**DA NO: MP 07 0094 MOD 4**

**PROPOSAL:** Salt Ash Sand Quarry Project  
**PROPERTY:** Nelson Bay Road, Salt Ash **NSW 2324**

Figure 2 – Proposed Quarry Layout

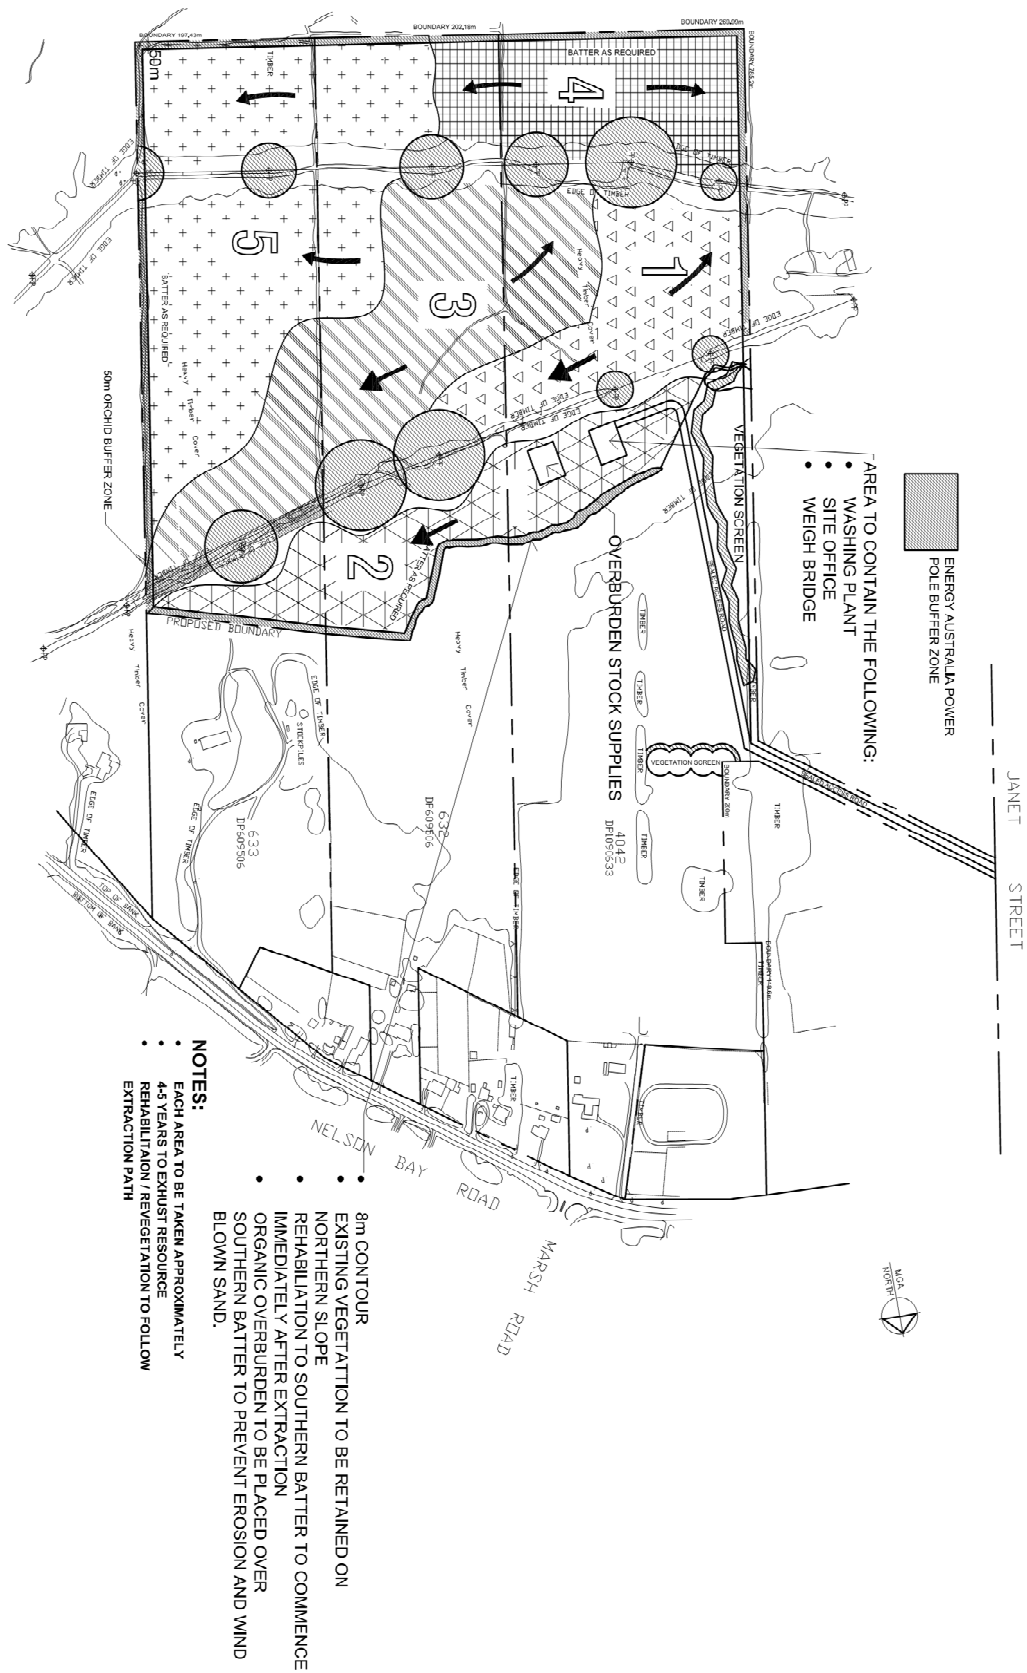
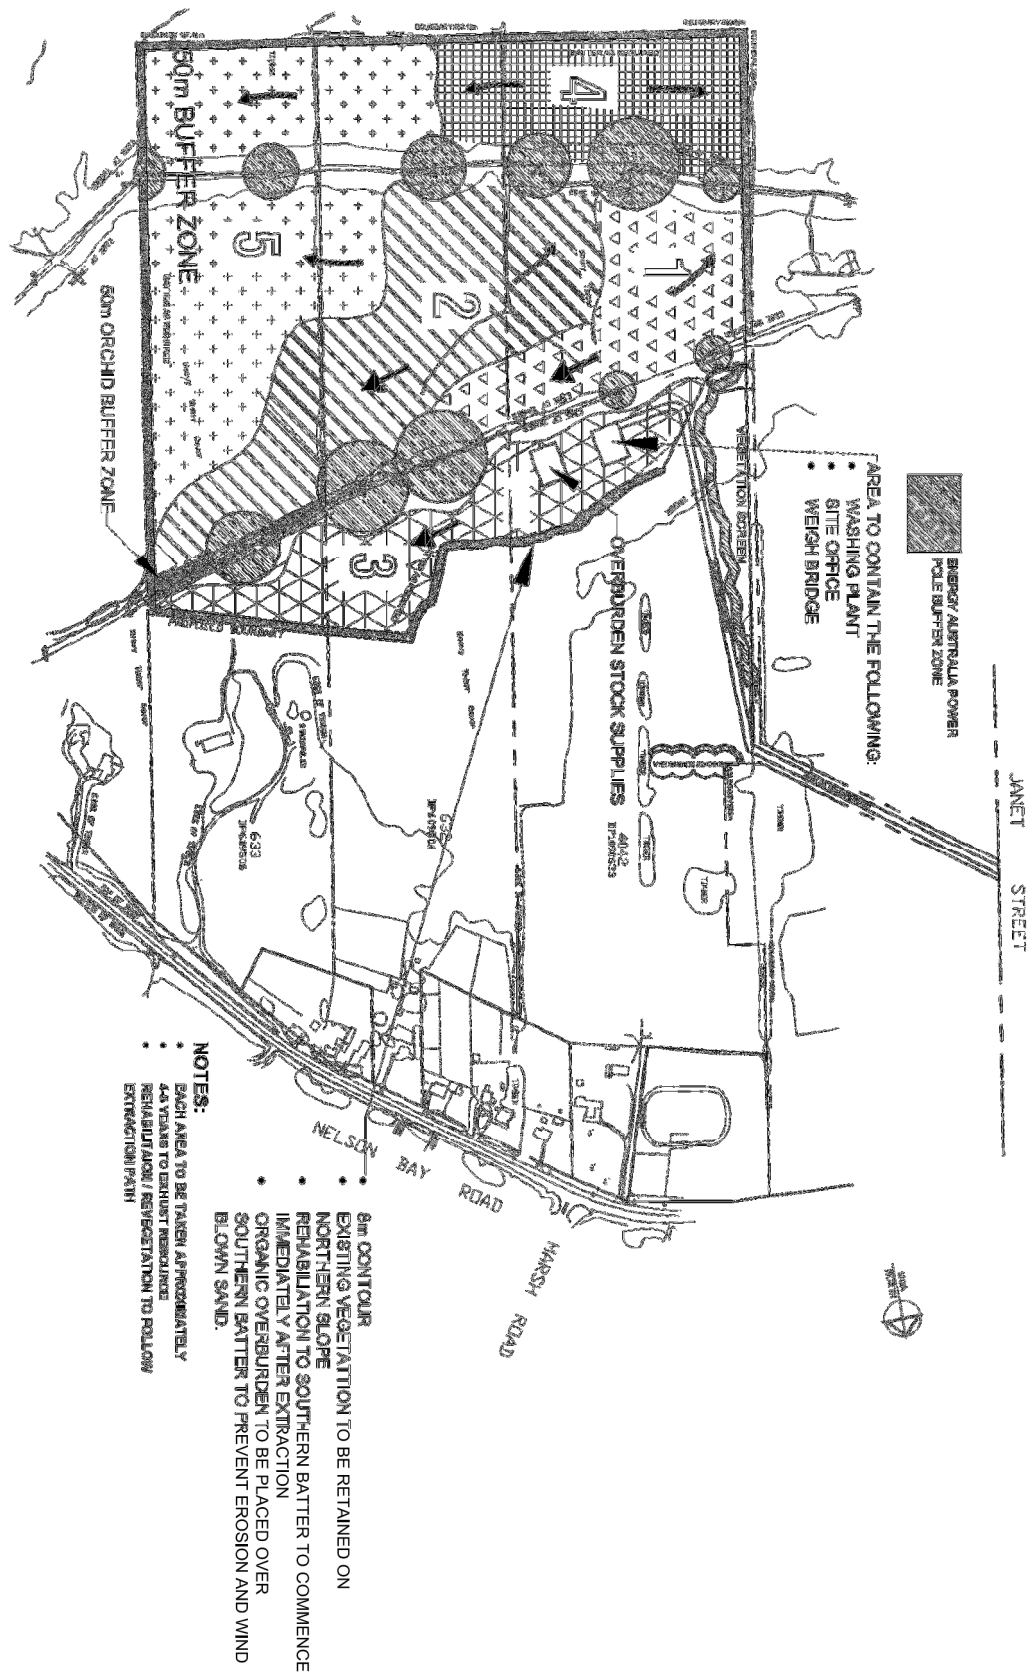
No confirmation could be located to show that changing staging would be consistent or inconsistent with the original ecology assessment. Further clarification of the potential impacts in regards to implementing staging to the proposed development is requested.
